Application number, type . . . : 17 50040951 CP NEW RESIDENTIAL (SFD)
Property address : 94554 *UNASSIGNED

Re: Engineering Services
2665 Ash Ave.
Dunn, NC

Tyndall Project No.: 1701-020196

APPLICATION # 1750040951
JOB NAME Rayford McCloud
DATE PLANS RECEIVED 6.3.17
SITE PLANS APPROVED Approved w/exception
APPROVED BY HS *WJ*

FIRST FLOOR PLAN
 1/8" = 1'-0" CEILING HT. = 7'-4"

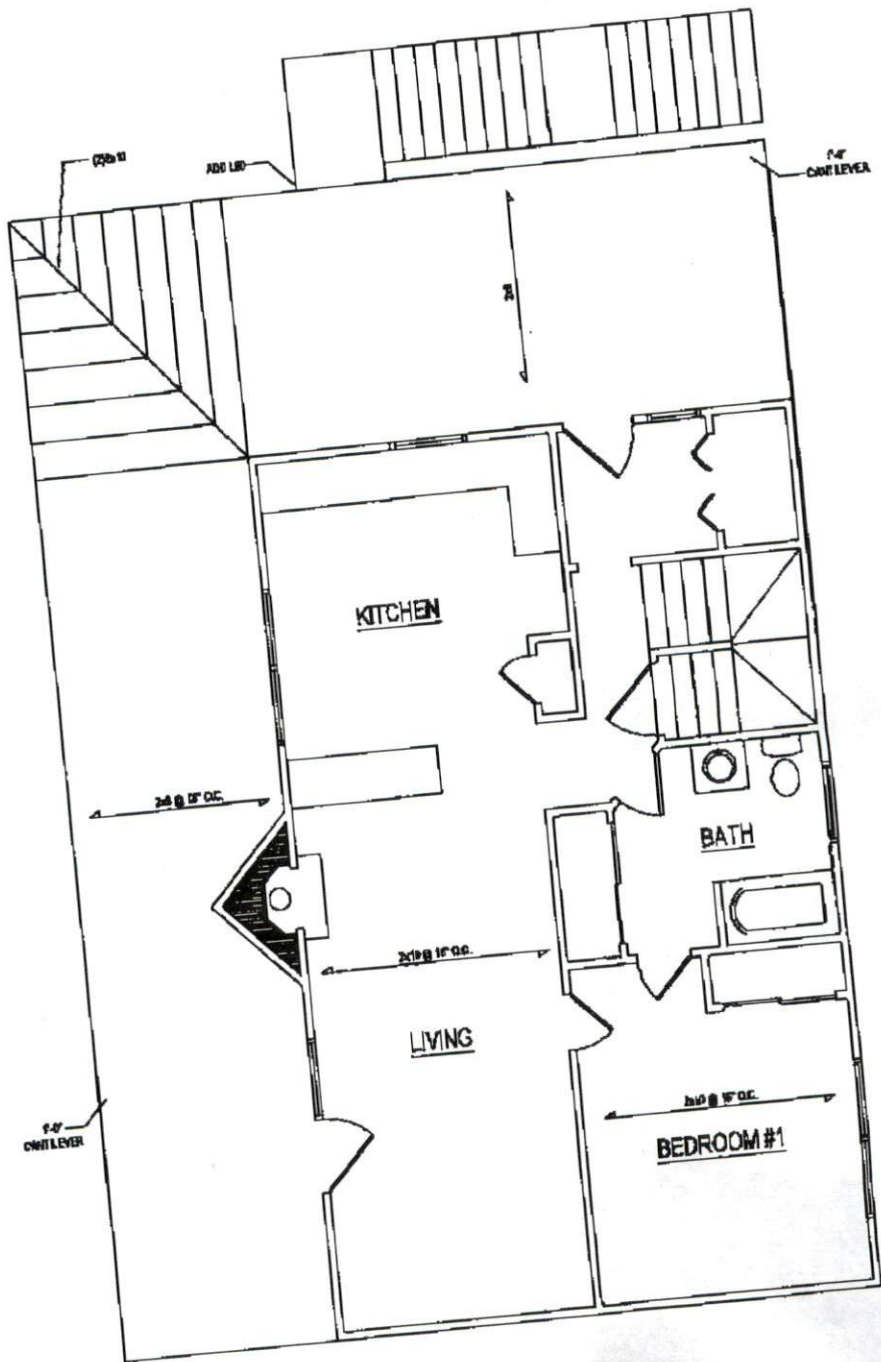
- 1) Floor joists associated with the ground floor were noted as being approximately 8" above the existing crawlspace grade. The existing floor joists were noted as being untreated 2x8 SYP joists placed at 16" O.C.
- 2) Untreated wooden girder members placed in direct contact with masonry associated with the girder support.
- 3) No means of foundation ventilation provided for crawlspace.
- 4) Minimum head height requirements (6'-8") not met at steps leading from 1st floor To 2nd floor.
- 5) Minimum head height requirements not met at 2nd landing encountered during ascension to 2nd floor.
- 6) Header not installed at single car garage door opening.
- 7) 1st floor wall studs 2x4 @ 16" O.C. in-lieu of code 2x6 for 3-story residential structure.

- 1) The joists' proximity to the finished grade does not meet the intent of the NC Residential Building code. TE&D recommends that this condition be addressed with the implementation of one (1) of the following options:

- a) Remove the existing subfloor to allow access to the floor joist. Apply a wood sealant/preservative product (such as Woodlife Coppercoat Wood Preservative) in accordance with all manufacturer recommendations.

- b) Remove the existing untreated floor joists and replace them with treated members.
- 2) Provide metal flashing between the bottom of the floor joists and the top of the masonry units so that no direct masonry/wood contact remains.

- 3) The foundation should be provided with a means of foundation ventilation. Non-typical vents (such as soffit vents) may be installed through the masonry foundation block. Based on our observations and analysis, approximately 64 sq. in. of ventilation is required. The recommended foundation vents should be installed on at least two (2) sides of the existing foundation.

- 4) This condition occurs at multiple points within the stair corridors. TE&D recommends rebuilding the staircases as necessary to provide minimum head height clearances (6'-8"). Note: Installing a spiral staircase may be an option that could be considered for this item.

- 5) Based on our observations and analysis, TE&D recommends that a (2) 2x10 (spf) header be installed at the location in question. Provide one (1) Jack stud and one (1) king stud at each end.

- 7) Based on our observations and analysis, 2x4 wall studs (approx. 7' height) are adequate to support the anticipated loading conditions. No action required.

SECOND & THIRD FLOOR PLAN

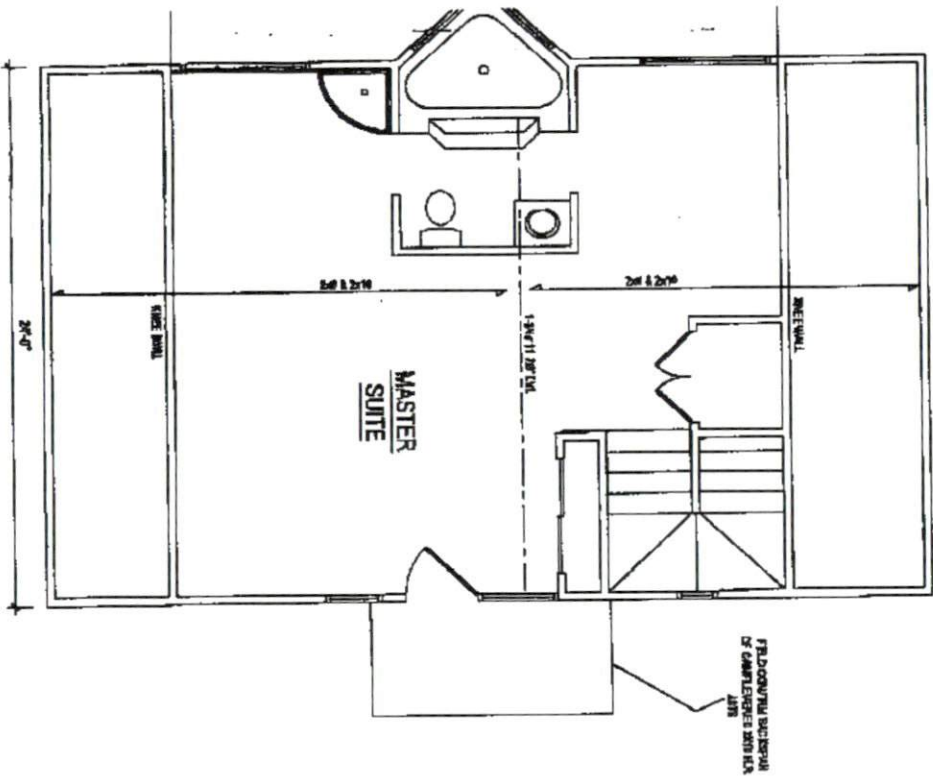
- 8) 4ft. Cantilever (2x10 floor joists) @ 3rd floor balcony.
- 9) Can't confirm roof support beam at covered porch roof located on right side of dwelling.

- 8) TE&D recommends that the backspan and supporting framing be field confirmed so that the joists may be properly analyzed.

- 9) TE&D recommends that the beam be field confirmed so that it may be properly analyzed. Our load estimates indicate that the beam should be on the order of a 3-1/2"x14" Parallam to adequately support the anticipated loading conditions.
